Subject: RE: BN/66/19 Canal Mews Barnham

Engineers Comments Regarding Surface Water Drainage

DRG.No.: 117/45

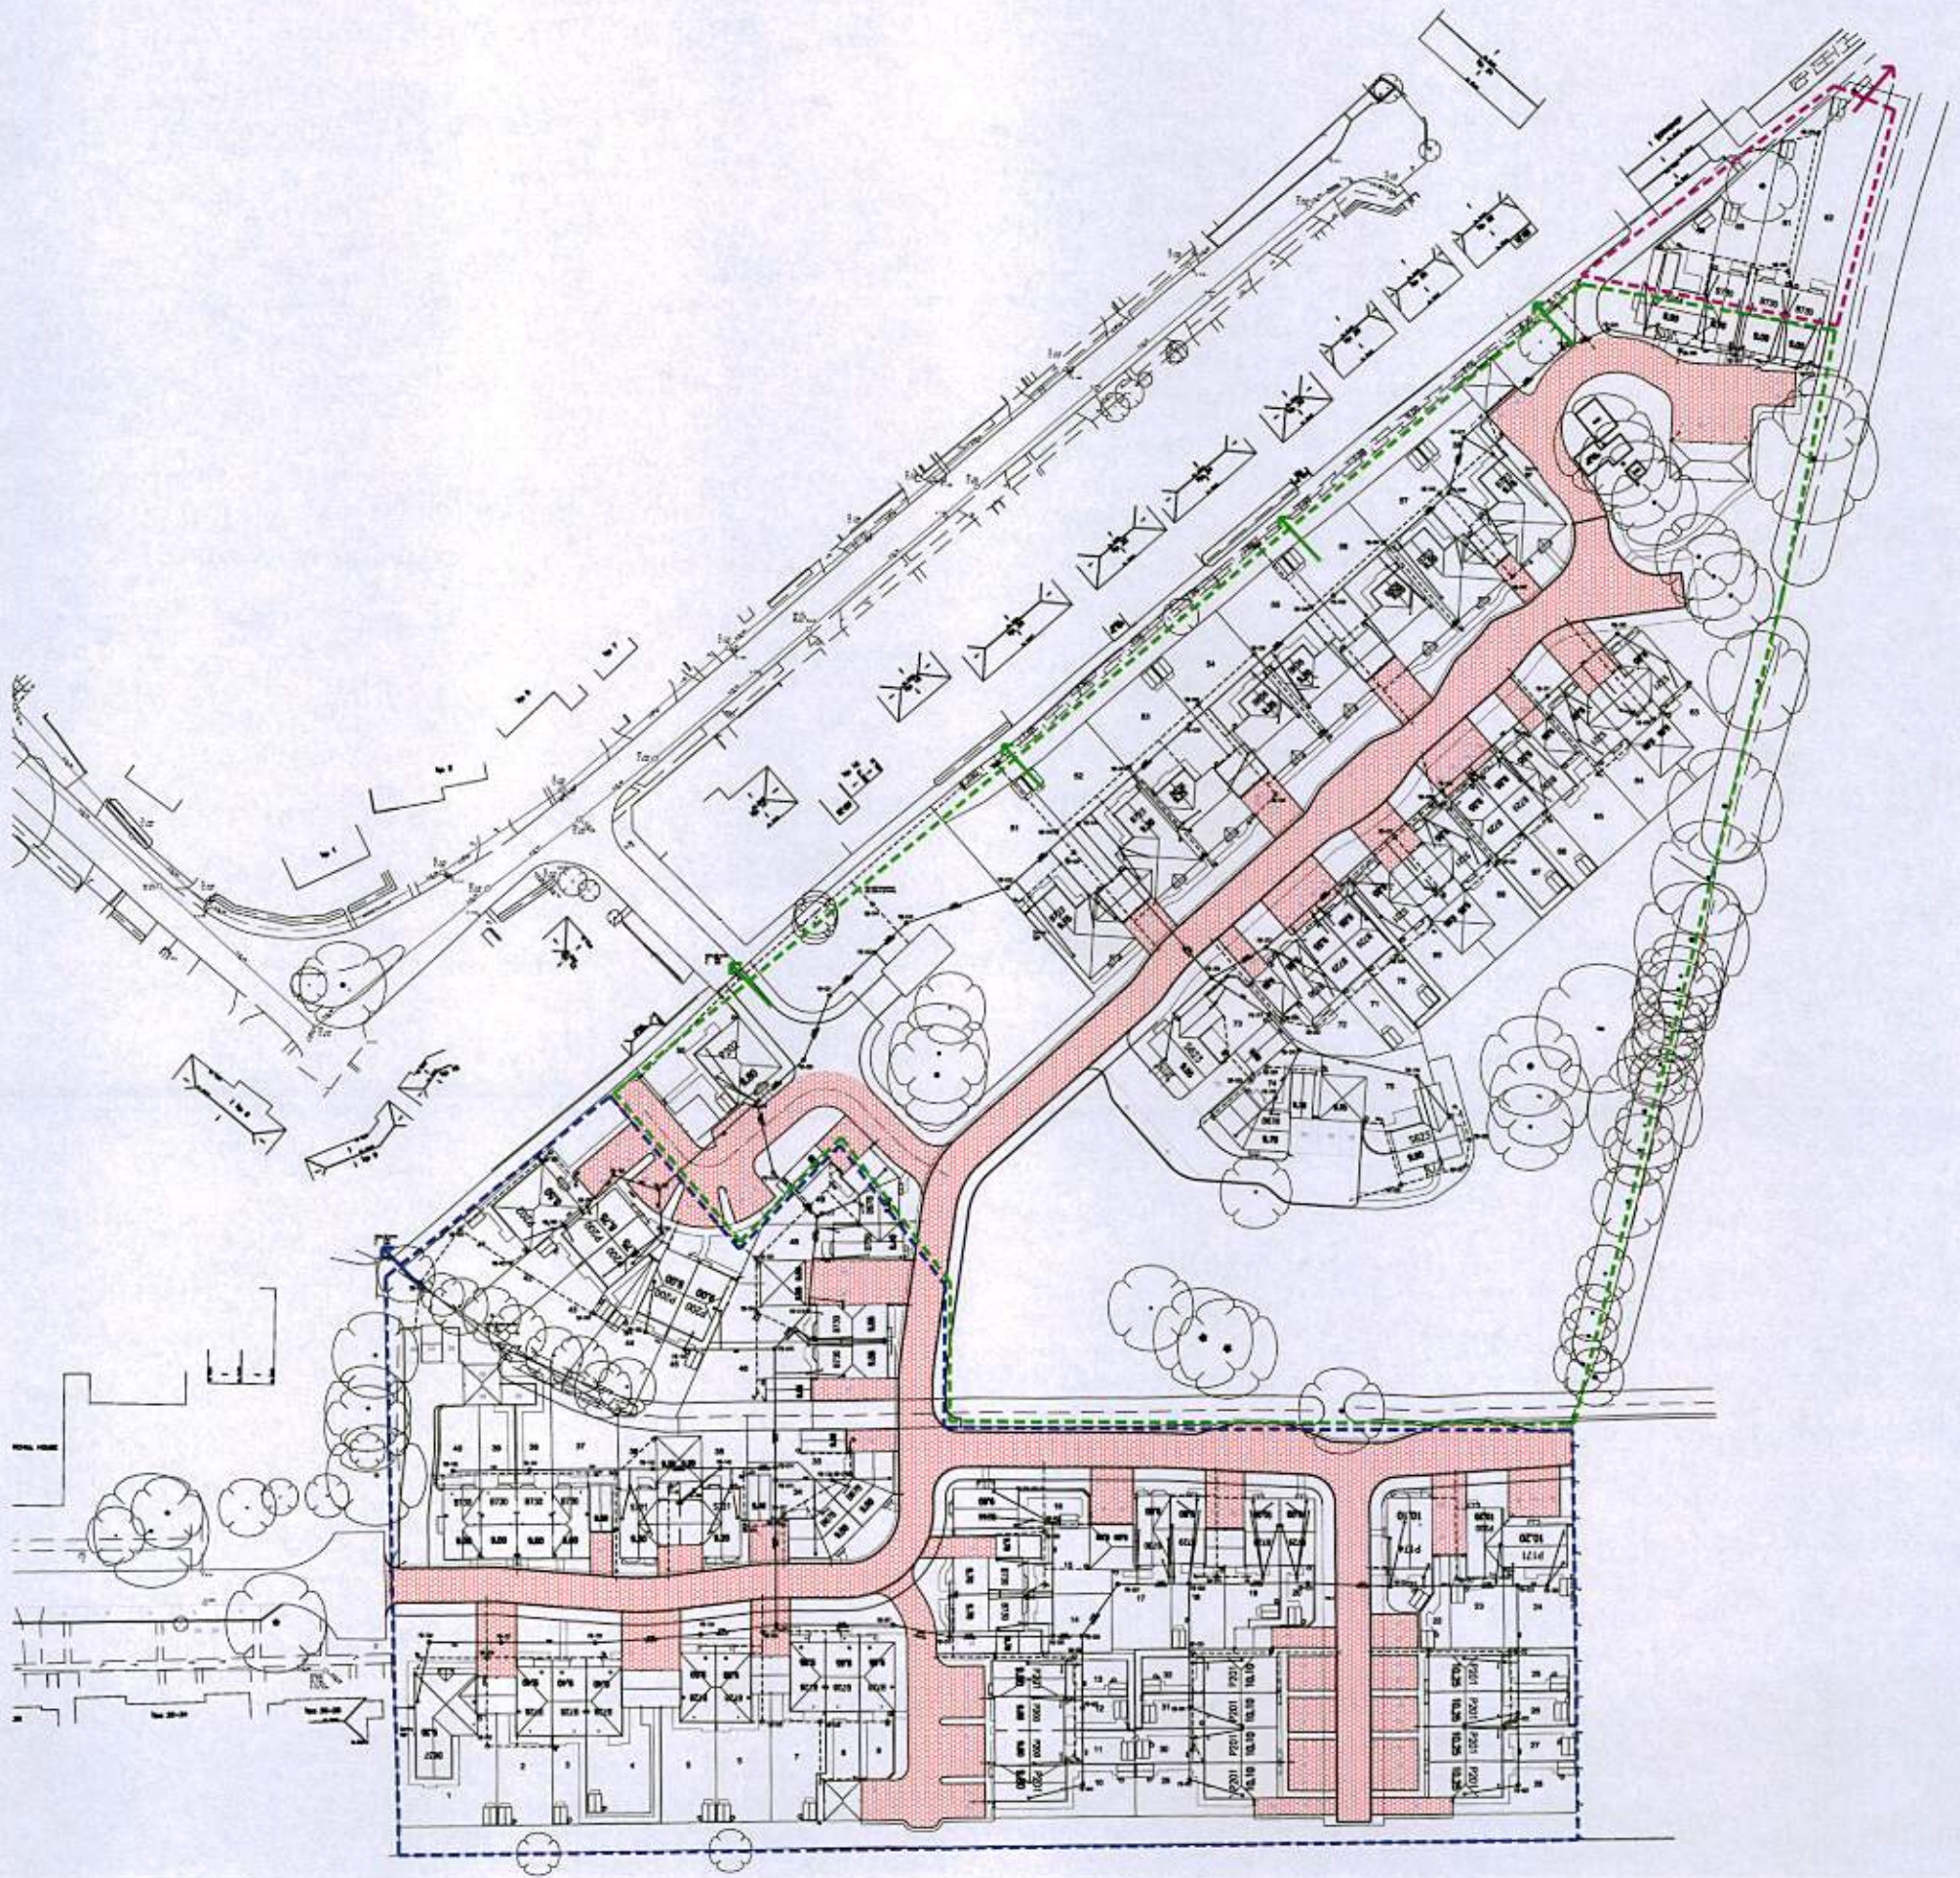
Please remove Laura Gibbons objection on this application. Whilst some surface water drainage information has been supplied we will require more detail on some elements including the historic percolation testing and it's location. Given that the applicant has stated a satisfaction with dealing with drainage via condition, if you are minded to approve the application please apply the following conditions to ensure that the development is adequately drained and does not increase flood risk elsewhere. If any further information/detail is supplied beyond what is available on this and application BN/25/14/DOC which may alter our assessment, then please reconsult this department.

"Development shall not commence, other than works of site survey and investigation, until full details of the proposed surface water drainage scheme have been submitted to and approved in writing by the Local Planning Authority. The design should follow the hierarchy of preference for different types of surface water drainage disposal systems as set out in Approved Document H of the Building Regulations, and the recommendations of the SuDS Manual produced by CIRIA. Winter groundwater monitoring to establish highest annual ground water levels and winter Percolation testing to BRE 365, or similar approved, will be required to support the design of any Infiltration drainage. No building / No part of the extended building shall be occupied until the complete surface water drainage system serving the property has been implemented in accordance with the agreed details and the details so agreed shall be maintained in good working order in perpetuity."
